Outline application with all matters reserved for the erection of 2 No. 3 bedroom semi-detached properties with integral garages & associated landscaping works. This application is a Departure from the Development Plan.

Land to the North of 68 Arundel Road Angmering

Thank you for your internet representation made on 9th May 2018 which has been recorded as '**an objection**' with the comments as follows:

TITLE:
RIGHT & LEFT
FLANK ELEVATION

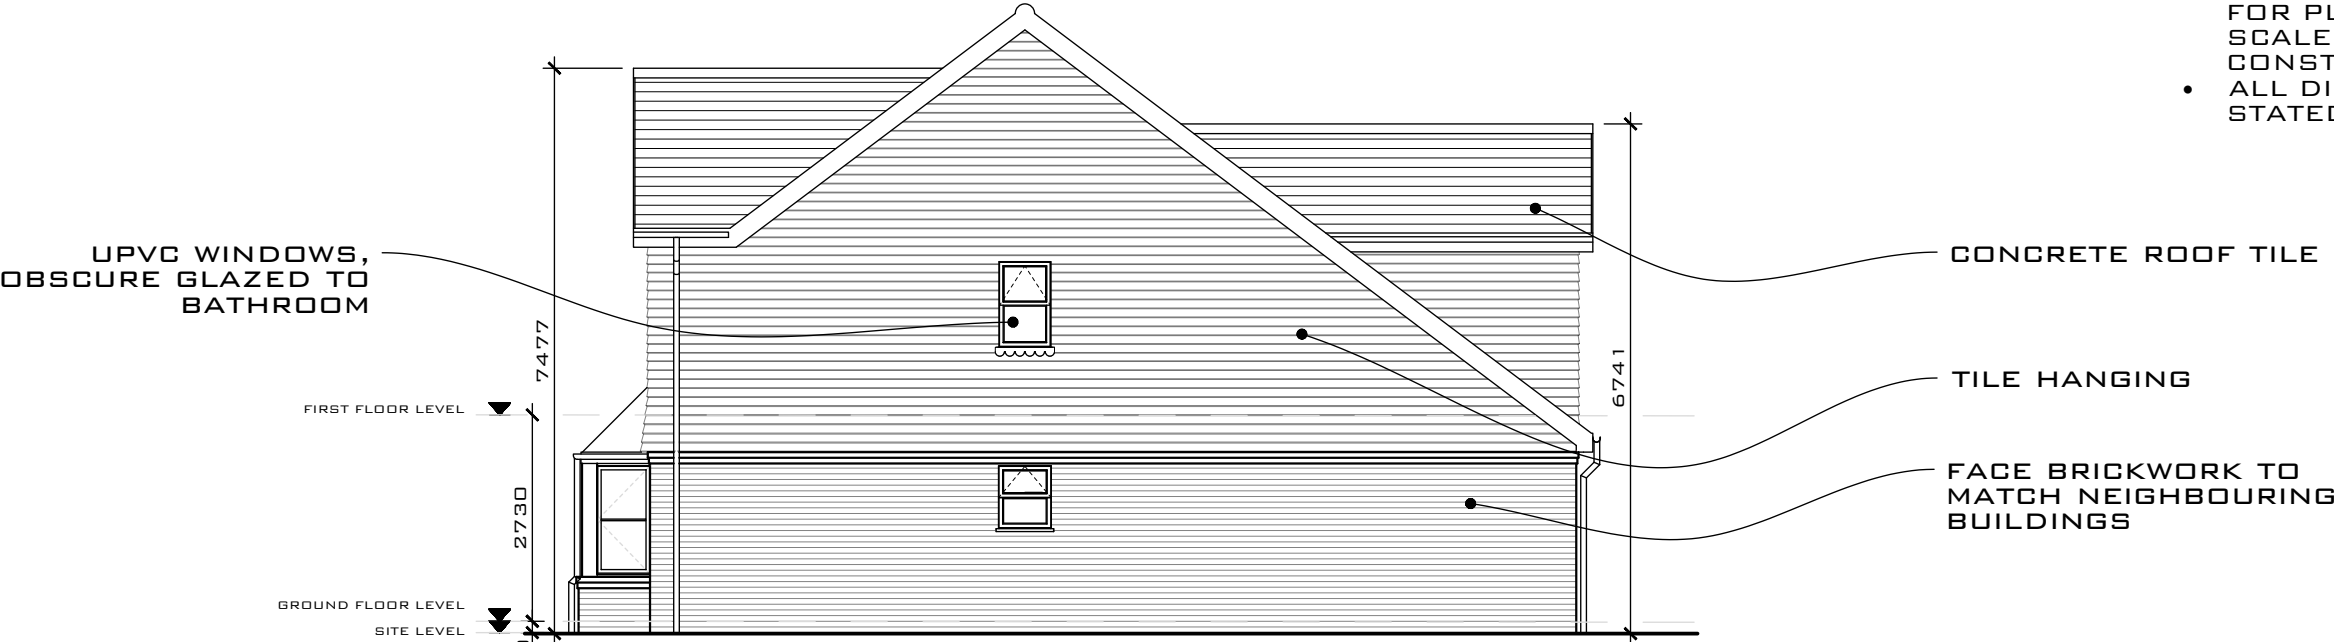
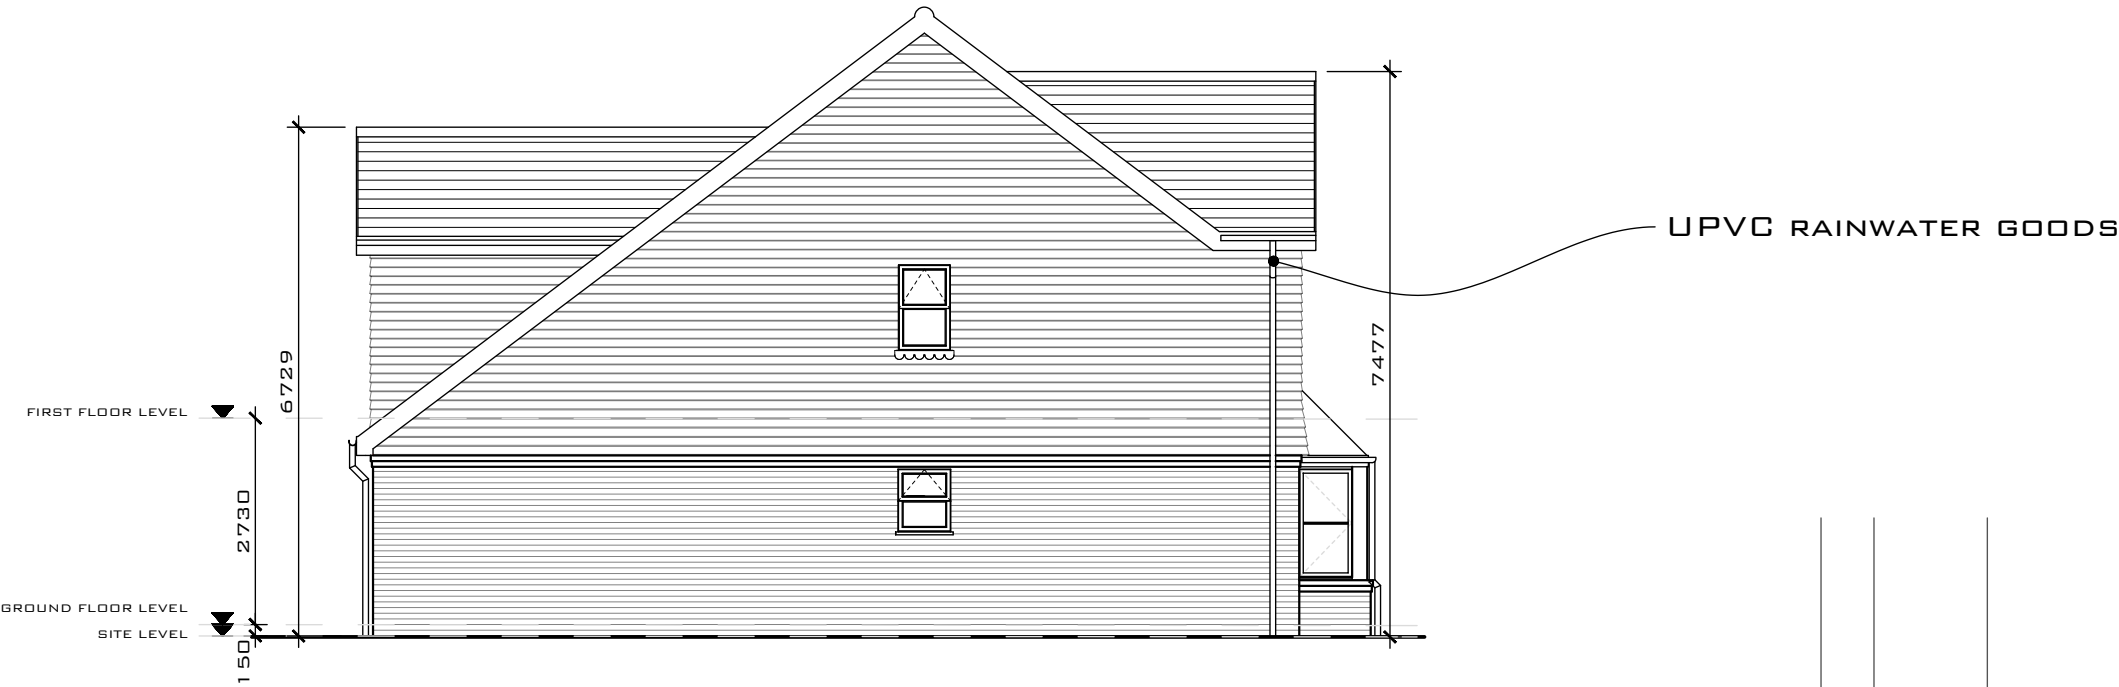
Given the position in the village and the adjacent houses which are bungalows my objection is to the proposed height of the development which would not be in keeping with the surroundings and adjacent property. A revised proposal for a bungalow or similar with lower roofline would be more appropriate.
